Your Ref: OWPC20786
Our Ref: FG/196/18/PL 26-10-2018
Please ask for:
Mrs A Gardner

Demolition of existing detached dwelling & detached garage & construction of 1 No. new detached dwelling.

12 West Drive Ferring

Proposed Rear (west) Elevation
Scale 1:100

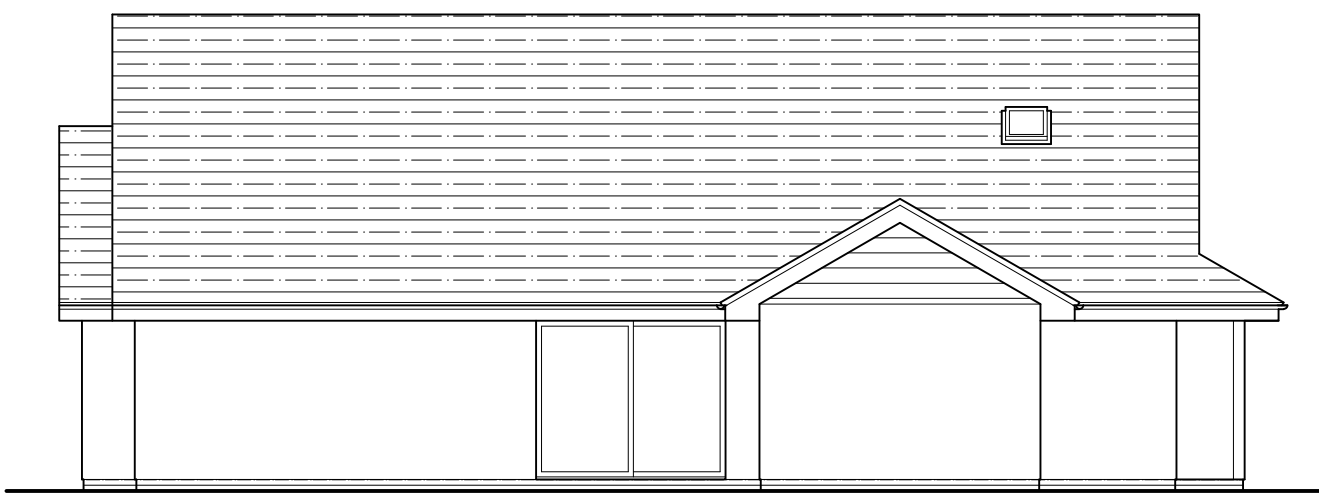
My wife and I would like to put in an objection to the purposed planning application at 12 West Drive (FG/196/18/PL). In the plans there is a large attic area to the rear of the house with a large window overlooking our property. As the tree in the rear garden was felled within days of purchase by the new owners, this window will give views into our house and garden and help to destroy the privacy our property has had over the years. If light is required in the attic space, might we suggest a Velux window in the roof would solve the problem for both sides.
